**City of Portland, Maine - Building or Use Permit**

Permit No: 10-0864	Date Applied For: 07/20/2010	CBL: 020 D010001
-----------------------	---------------------------------	---------------------

Location of Construction: 85 INDIA ST	Owner Name: 85 INDIA STREET LLC	Owner Address: 85 INDIA ST	Phone:
Business Name:	Contractor Name:	Contractor Address:	Phone:
Lessee/Buyer's Name	Phone:	Permit Type: Change of Use - Commercial

Proposed Use: To change the use to- First floor: office (Wildwood medicine) and retail uses - 2nd floor: offices - 3rd floor: 1 dwelling unit	Proposed Project Description: To change the use to - 1st floor: office (Wildwood) and retail - 2nd floor: offices - 3rd floor 1 dwelling unit
--	--

FIRE ESCAPE 85 INDIA ST.
PLOT PLAN

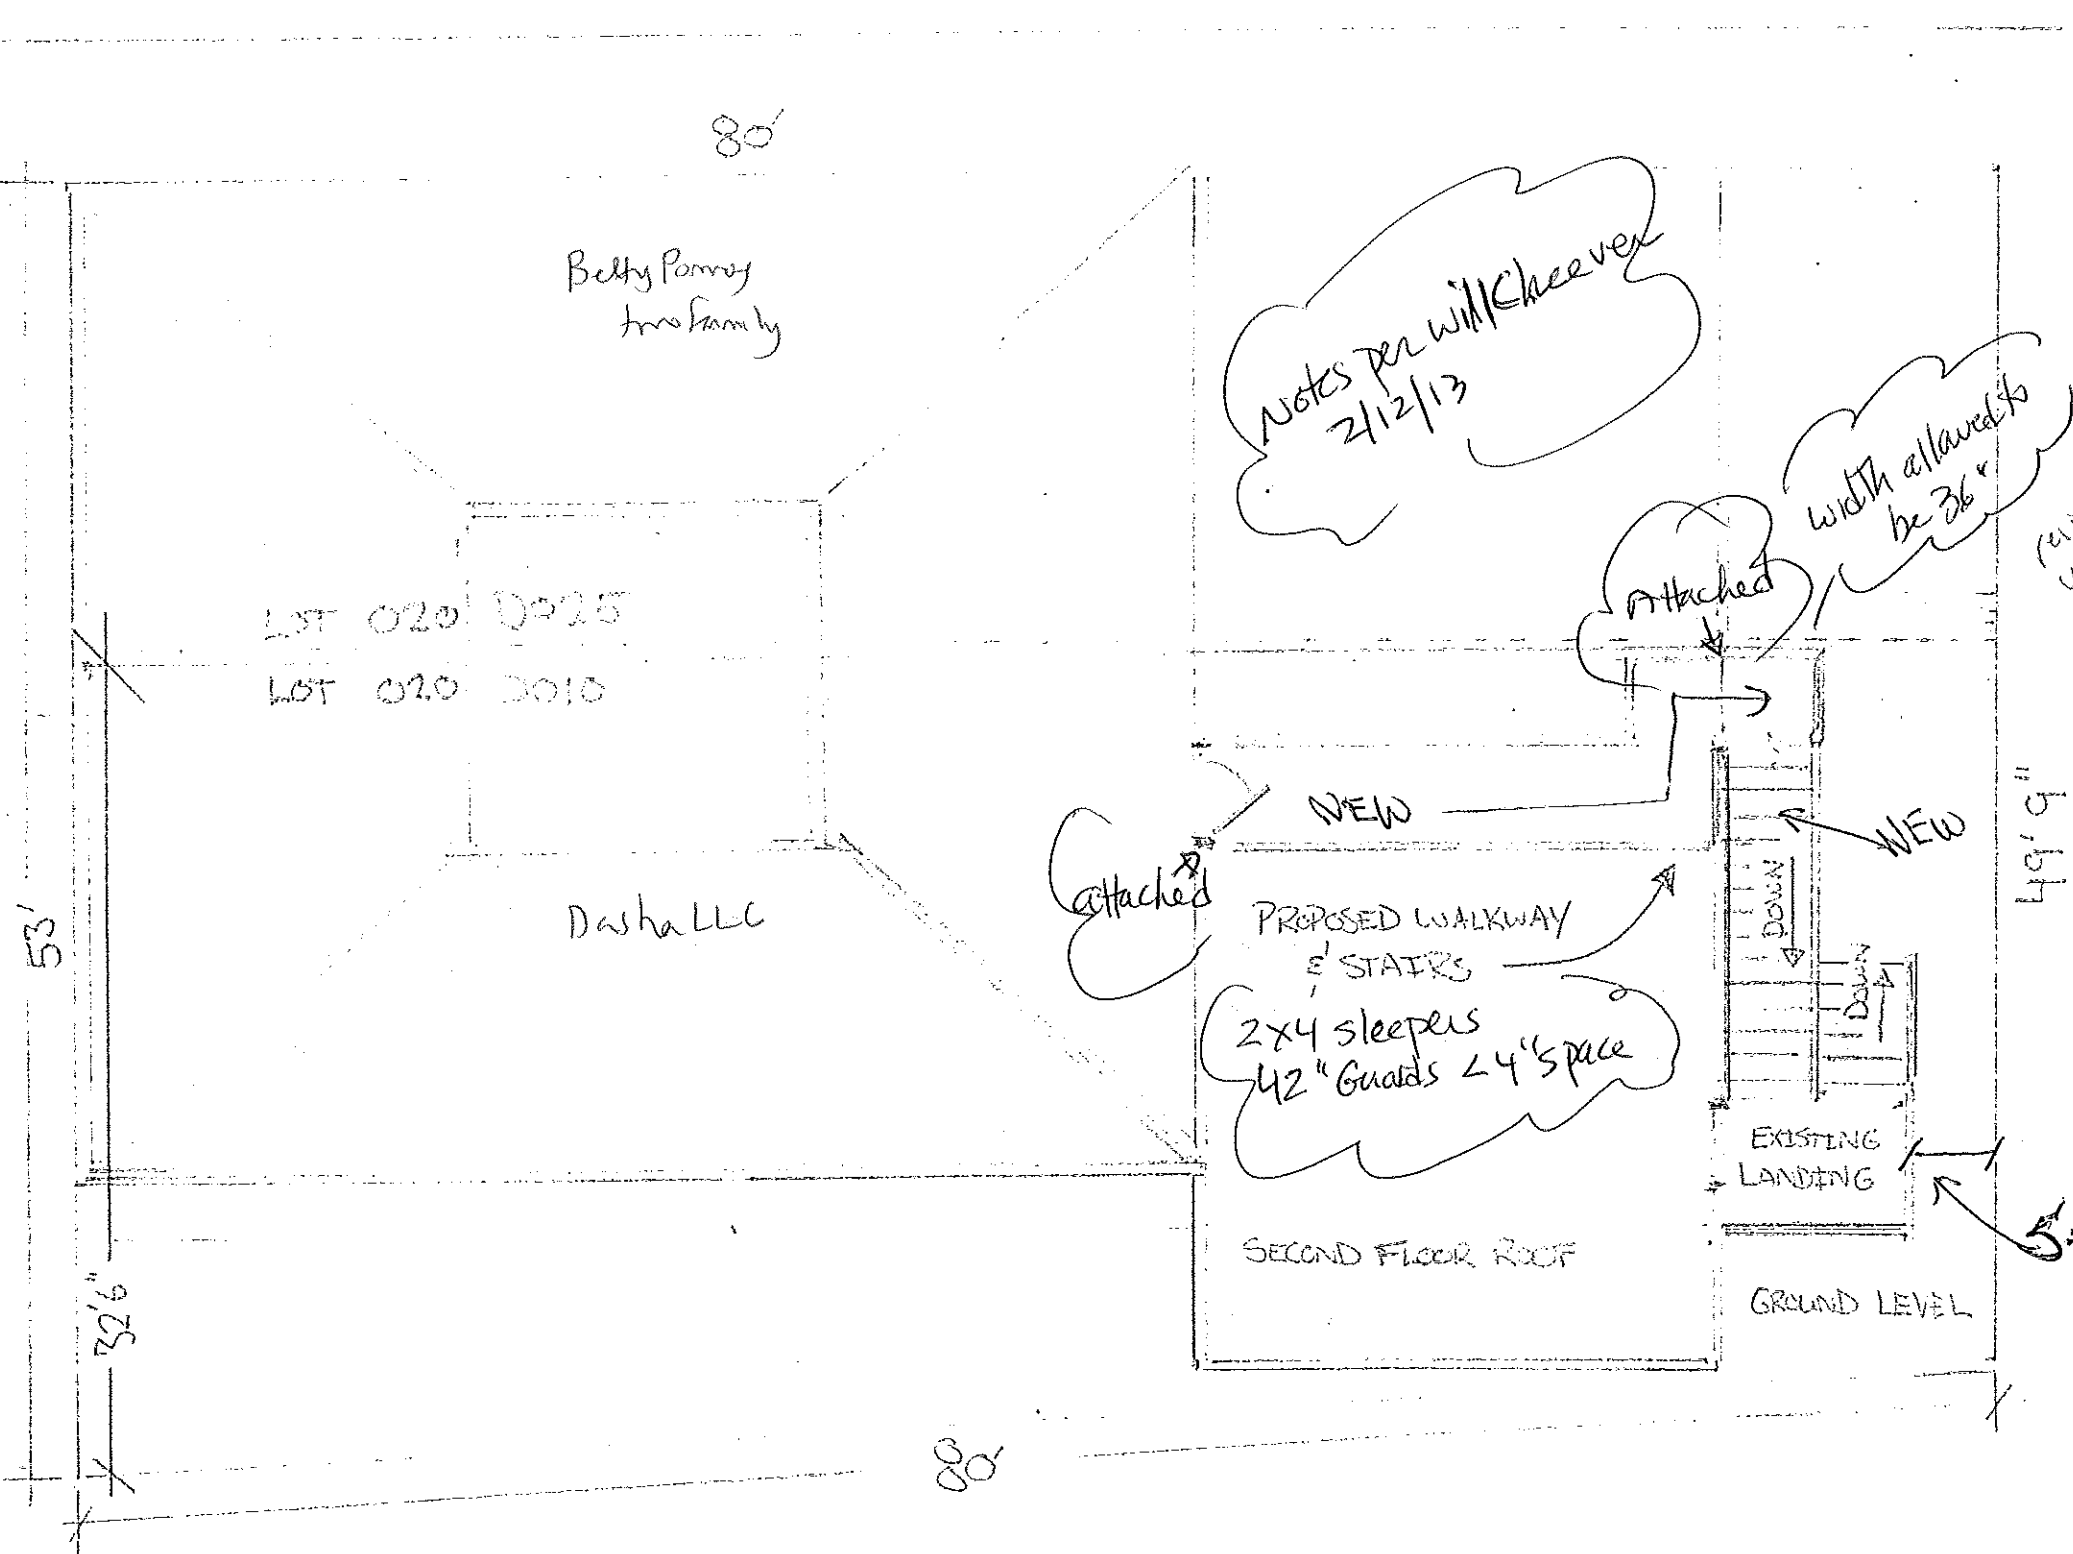
<p><b>Dept:</b> Fire      <b>Status:</b> Approved with Conditions      <b>Reviewer:</b> Ben Wallace Jr.      <b>Approval Date:</b> 08/02/2010</p> <p><b>Note:</b> Third floor shall remain unoccupied. No second means of egress.      <b>Ok to Issue:</b> ✓</p> <p>1) Second floor rear exit shall discharge directly to city street with out obstruction.</p> <p>2) Third floor shall remain unoccupied. No second means of egress.</p> <p>3) A knox box is required.</p> <p>4) A fire alarm system is required. A seperate fire alarm permit has already been approved.</p> <p>5) Structure shall comply with NFPA 101 for existing mercantile use front half of first floor and existing business use of rear half of first and all of second floor.</p>
